Letter No. A2/30070/97 dated 8.1.1998

Sub: Chennai Metropolitan Development Authority, -

Planning permission - Construction of GF+FF
residential building at S.No.188/53 of Porur
village - Development charges and other
charges to be remitted - regarding.

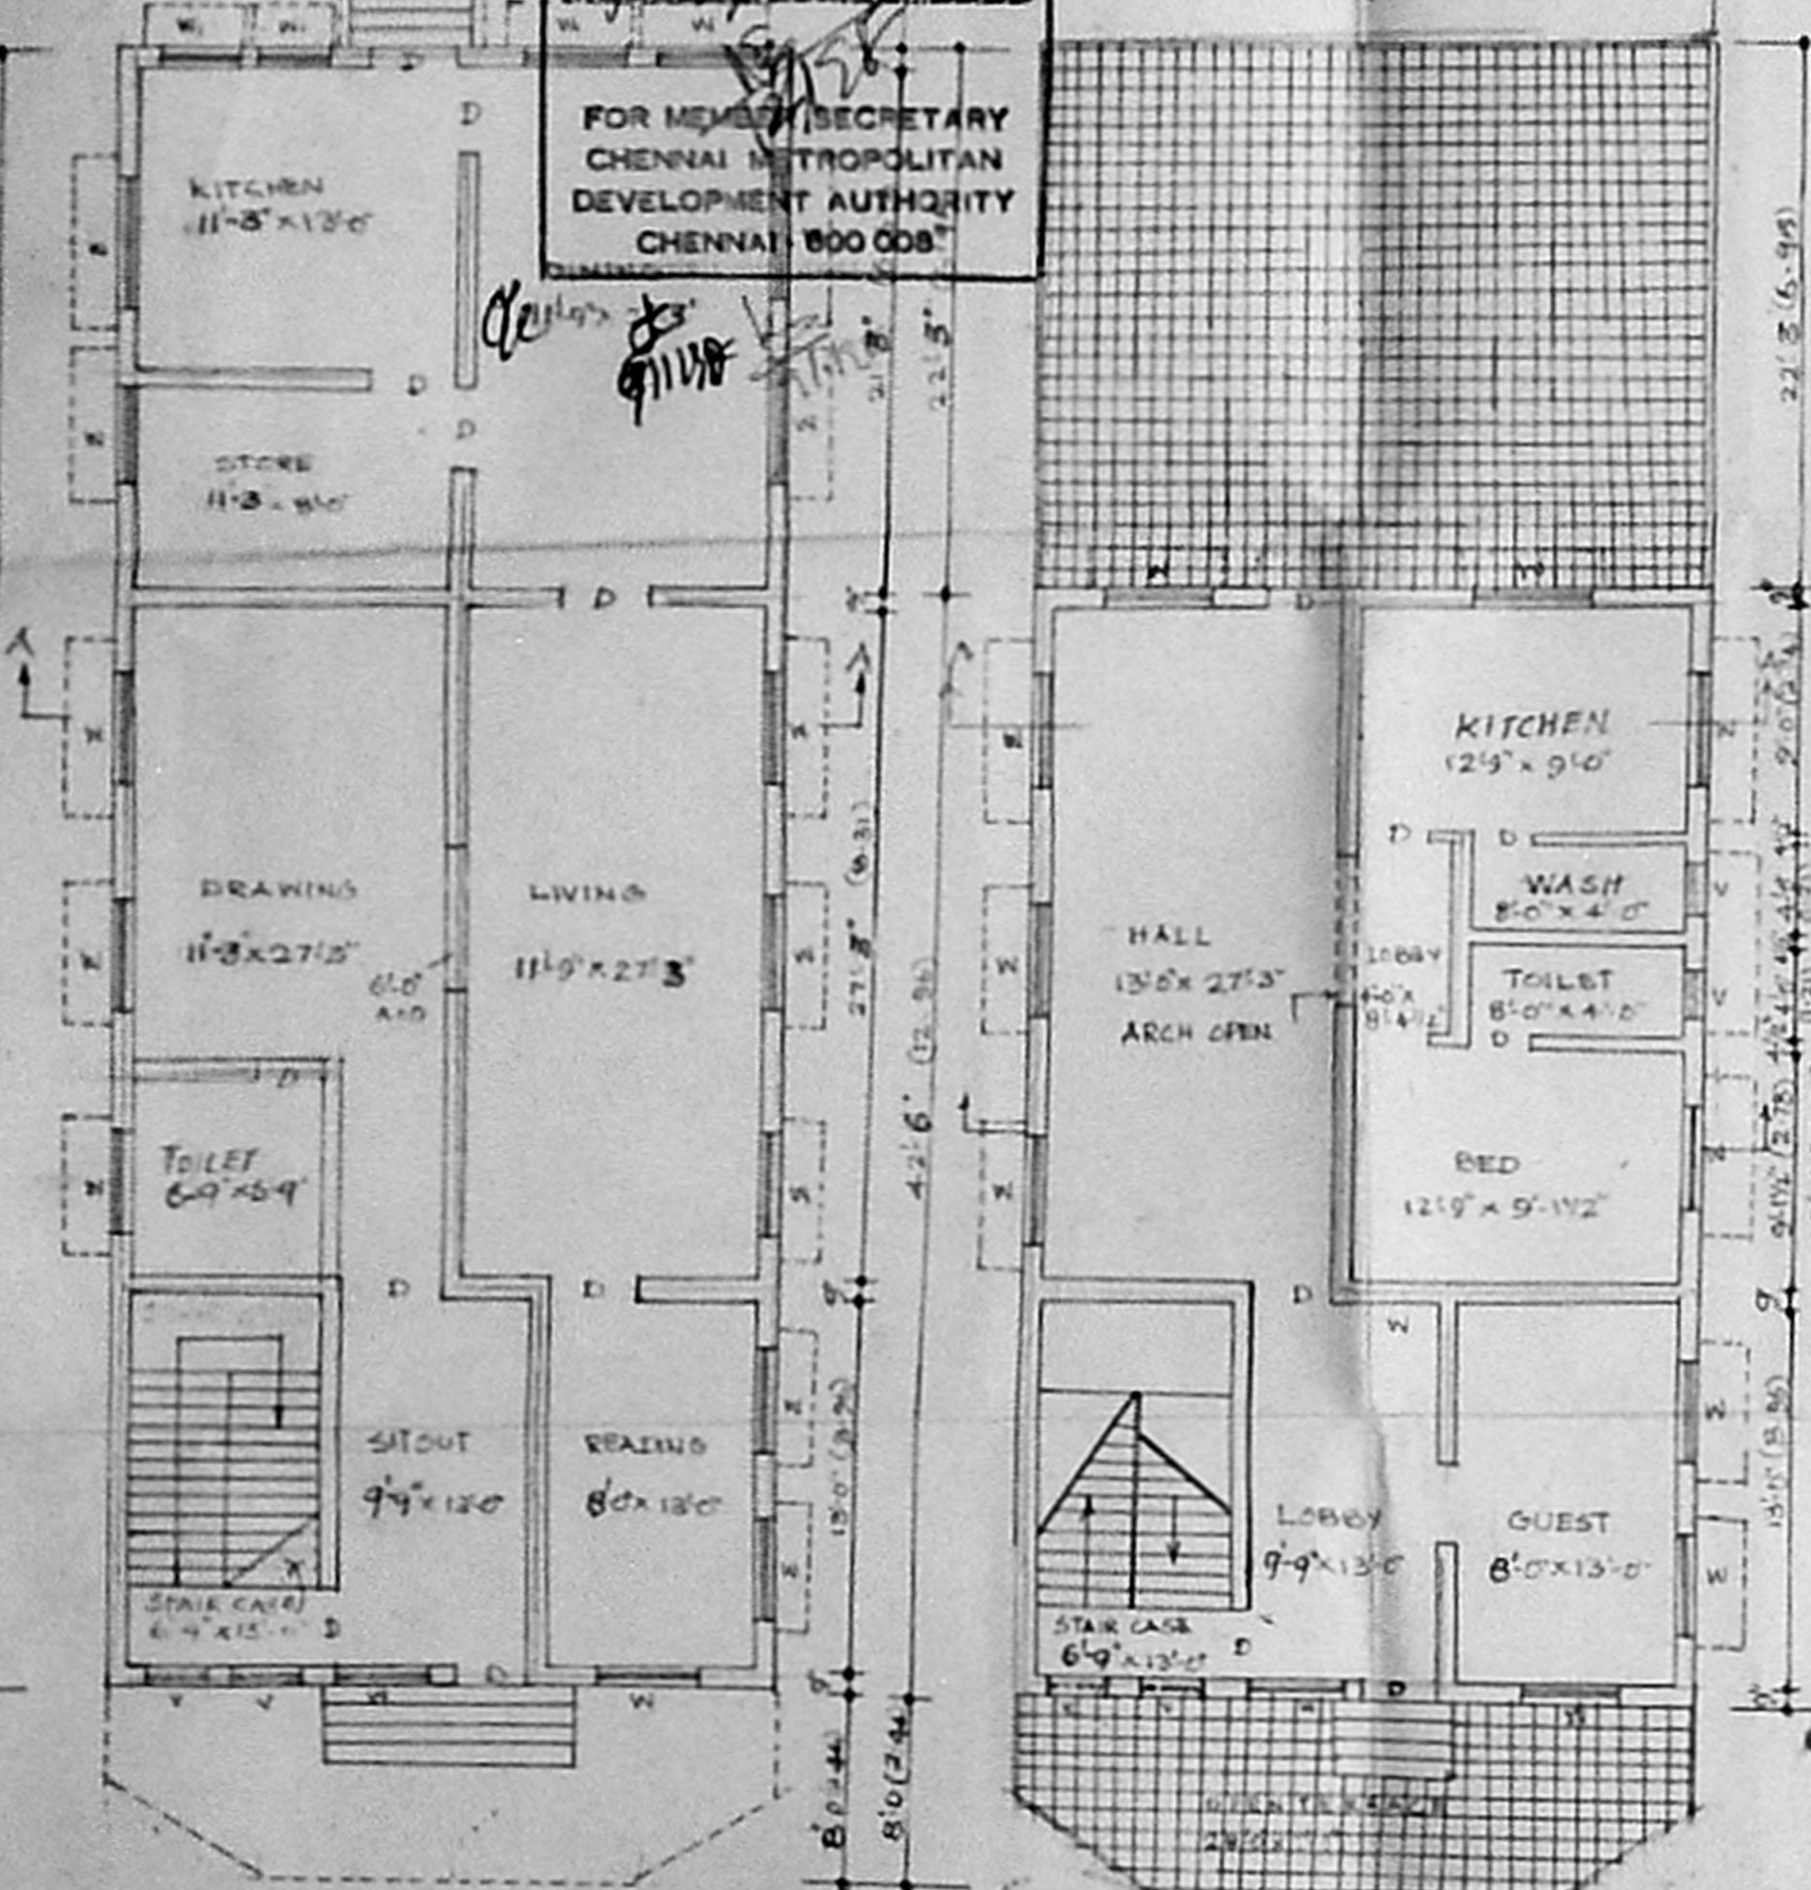
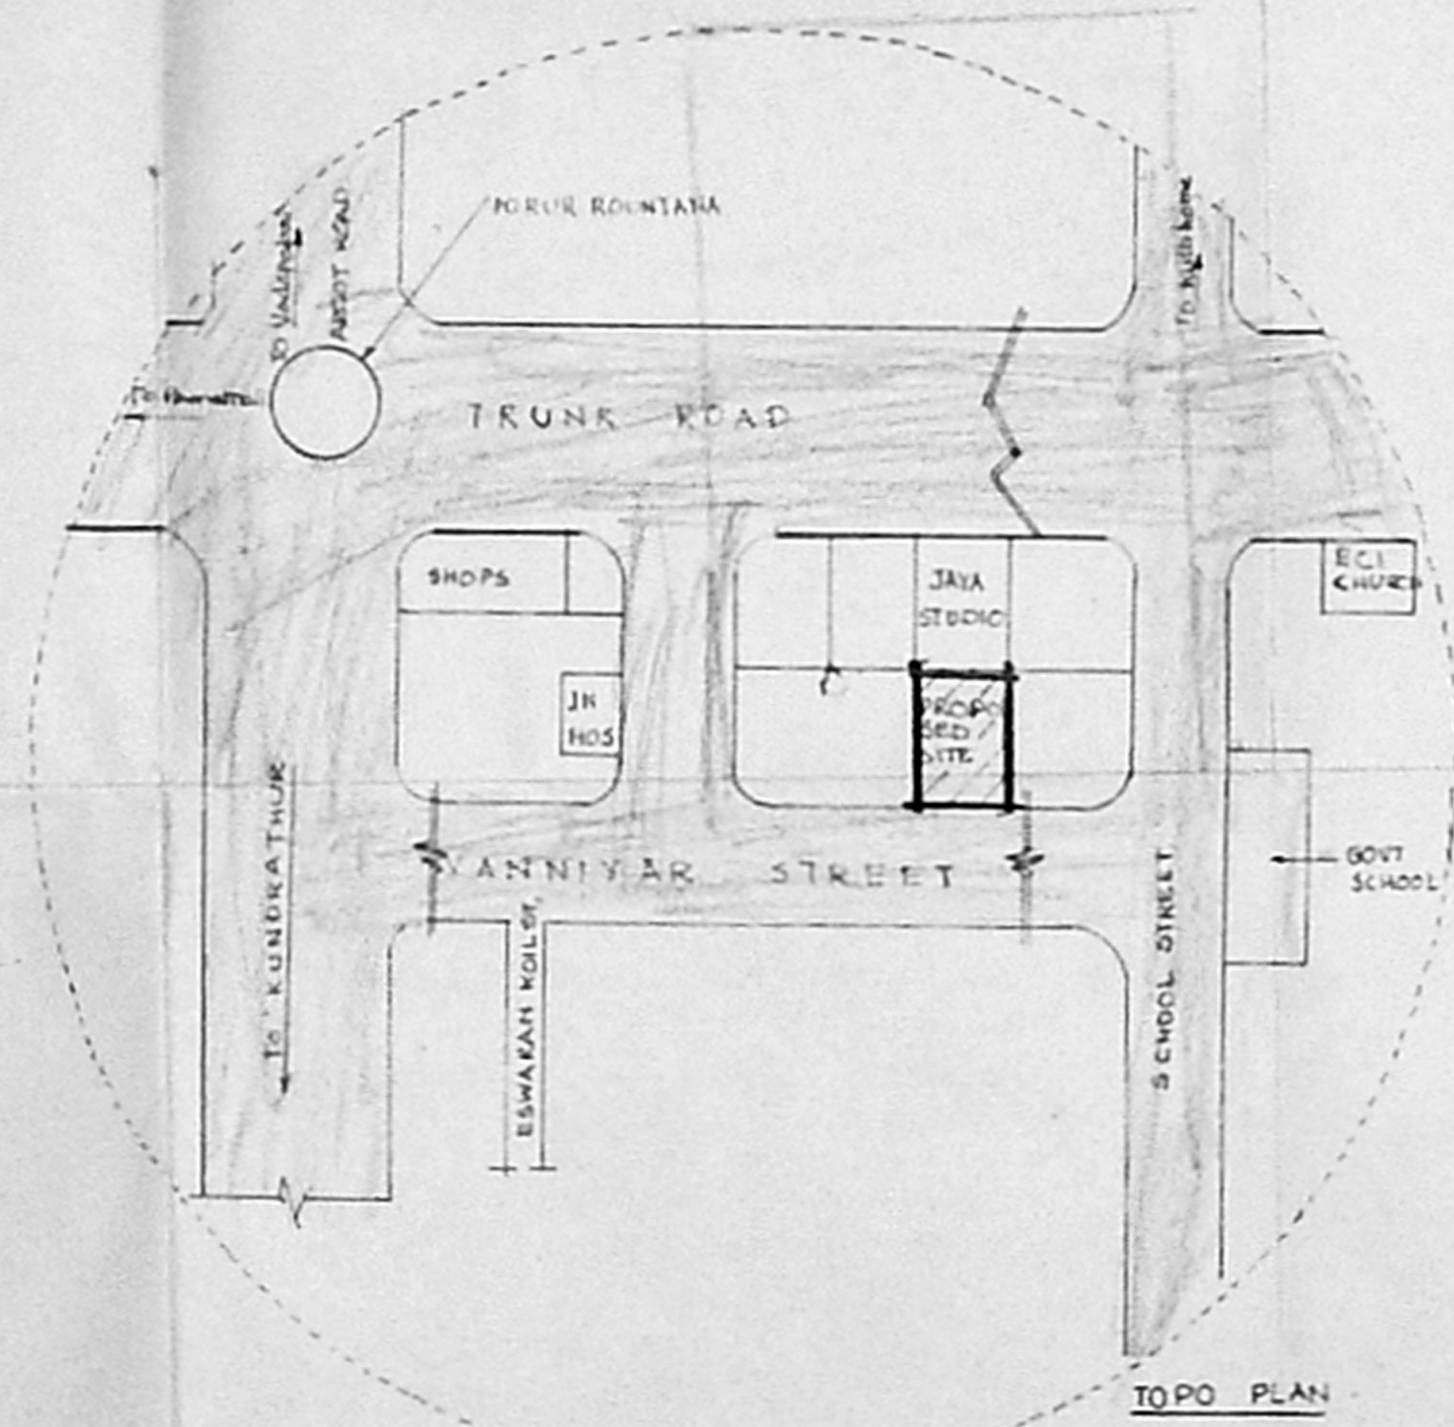
b) Five copies of revised plan mentioning the correct road width and name of the road.
